**KIRKLEES METROPOLITAN COUNCIL  
INVESTMENT & REGENERATION SERVICE**

**DELEGATED DECISION TO DETERMINE PLANNING APPLICATIONS**

Reference No:	<b>2023/62/93773/W</b>
Site Address:	Manashay House, 115, Upper Brow Road, Paddock, Huddersfield, HD1 4UP
Description:	Erection of gabion basket retaining wall
Recommending Officer:	Tom Hunt

## **OFFICER REPORT – 2023/93773– Erection of retaining wall**

Drawing No.
1101

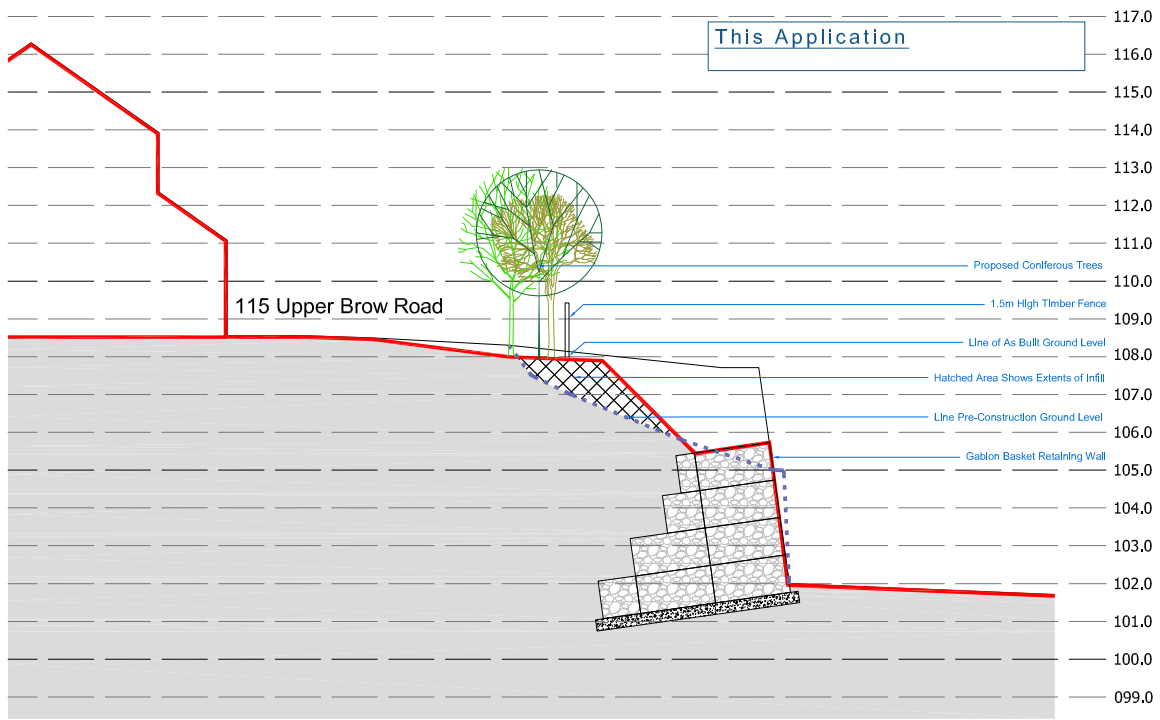
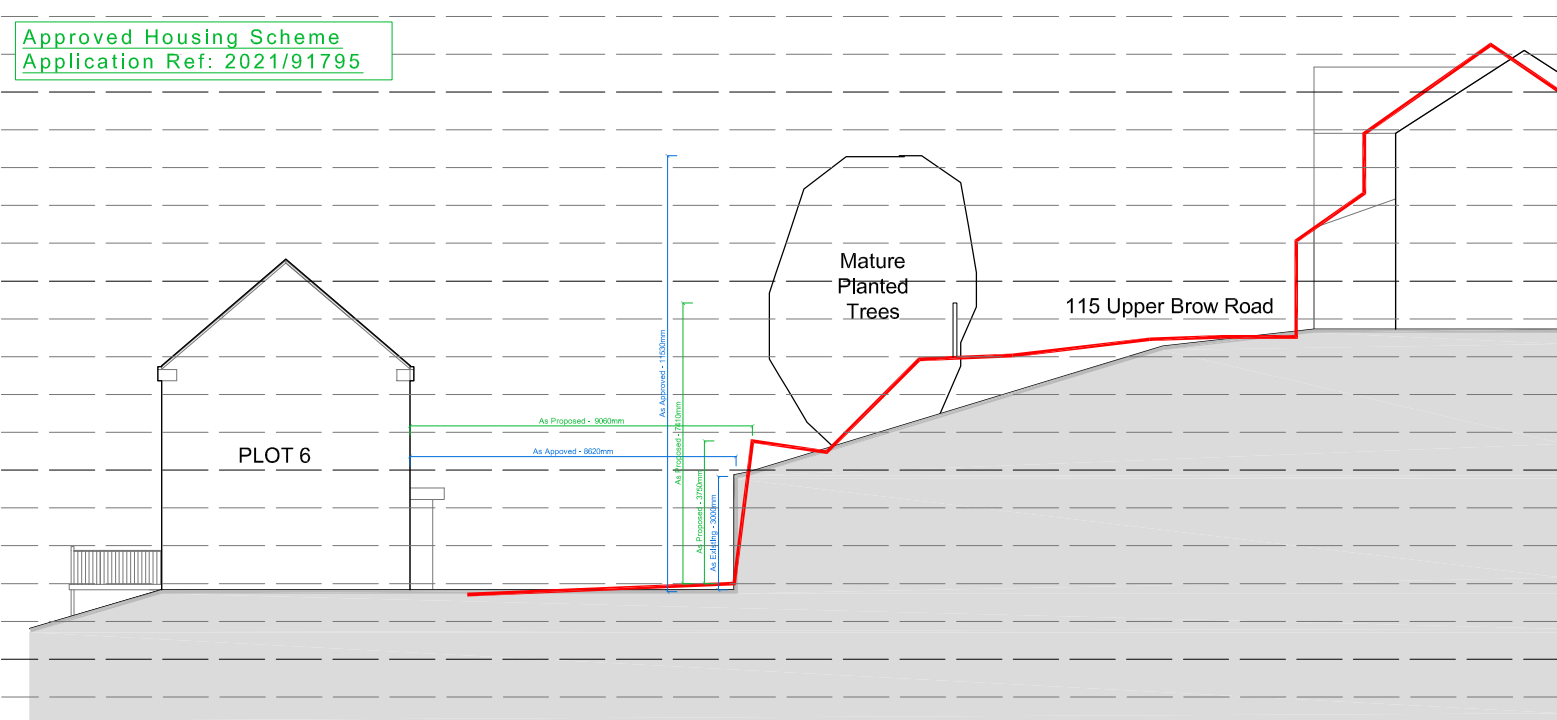
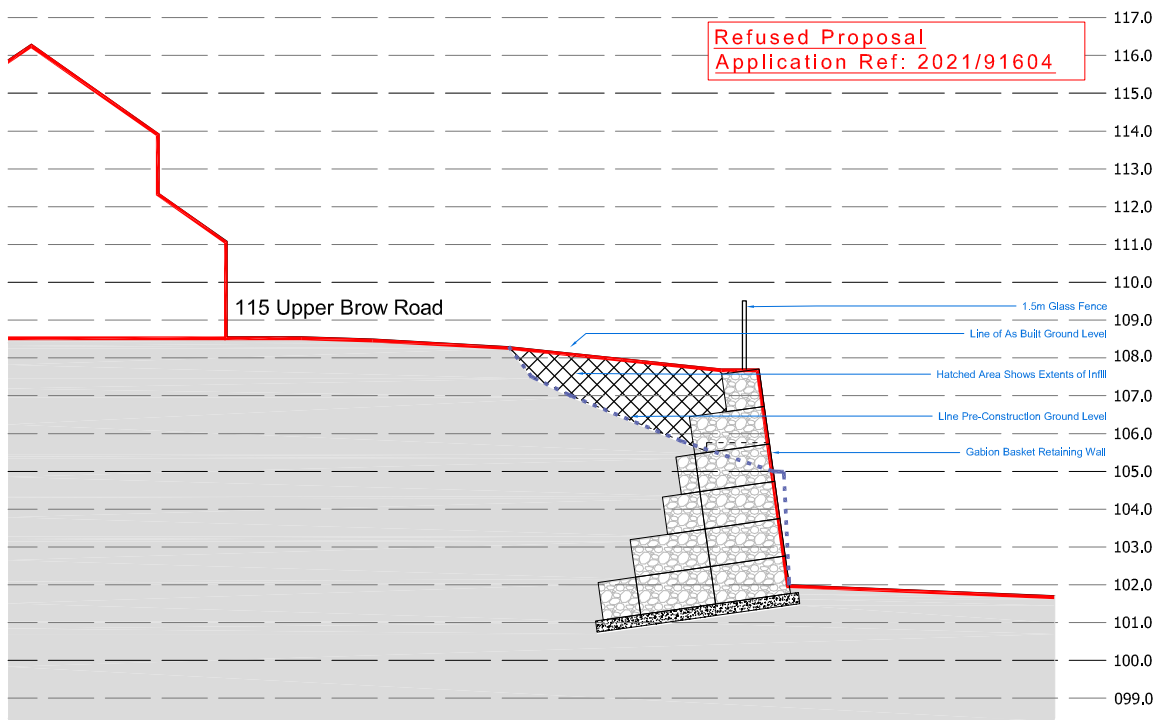
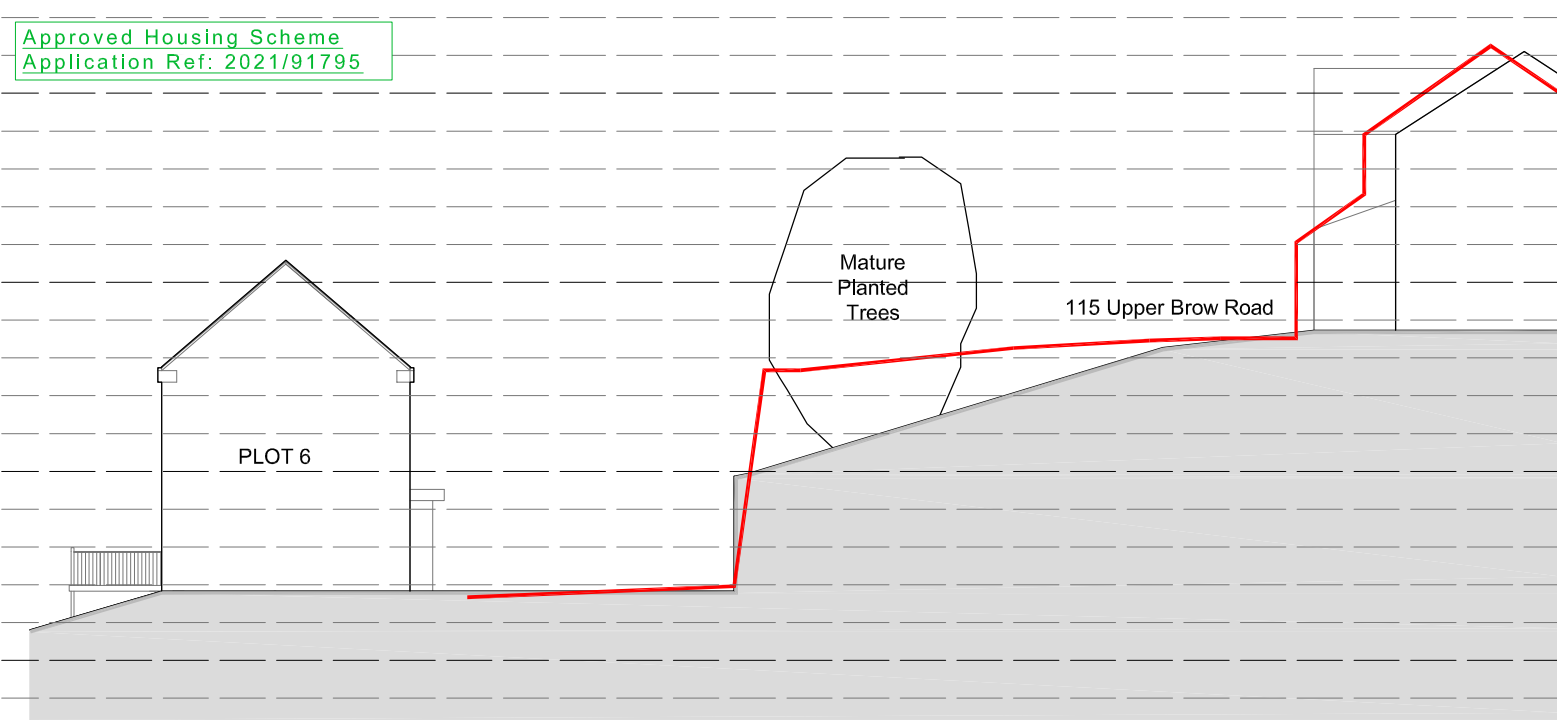
4.4 Comparing the original application for the Erection of a Retaining Wall - **2021/91604** – this submission still proposes to retain the gabion walling at over 3m in height, limited sectional information has been provided, and does not propose to batter back the land as required in the enforcement notice. Some additional ‘justification’ has been provided in support of the revised proposal (particularly in section 2 of the design and access statement). It is noted that the Enforcement Notice stated that the applicants are directed to permanently reduce the height of the gabion basket retaining wall to a height not exceeding 3 metres measured from natural ground level. This would include all sections of the retaining wall, such as the new ~2.0m to ~2.8m metres height section of the retaining wall above the existing historic retaining wall. The application submission is silent on this.

- 4.7 Within the Statement, it provides an Existing Site Section with Proposed Adjacent Dwelling as Approved in 2021/91795, which is not to scale but is annotated with heights and widths in millimetres. This includes one of the proposed houses affected within application 2021/91795 and comments that it would increase the separation distance of the previously existing retaining wall (3m height from ground) with the proposed being 0.5m further but with an increased height of 3.75m from ground and omits to reference the overall increase in regraded land behind the retaining wall. Officers note that this pertains to one very limited section and does not provide specific details which would alter the overall proposal as assessed in application 2021/91604.

- 4.8 The Statement erroneously states that the ‘proposed’ height is 4m lower than the ‘existing’ however Officers had assessed the same proposal in 2021/91604 and there had been no alteration in assessed height in the current proposal 2023/93773. The ‘existing’ height is the original height of the original retaining wall.

- 4.10 No significant amendments are proposed to conclude that the harm under Reasons one and two of the 2021/91604 decision would be overcome. There is limited sectional information and no clear demonstration how an effective landscape proposal would be undertaken in a narrow strip of land. In respect of Reason 3, Officers do not have
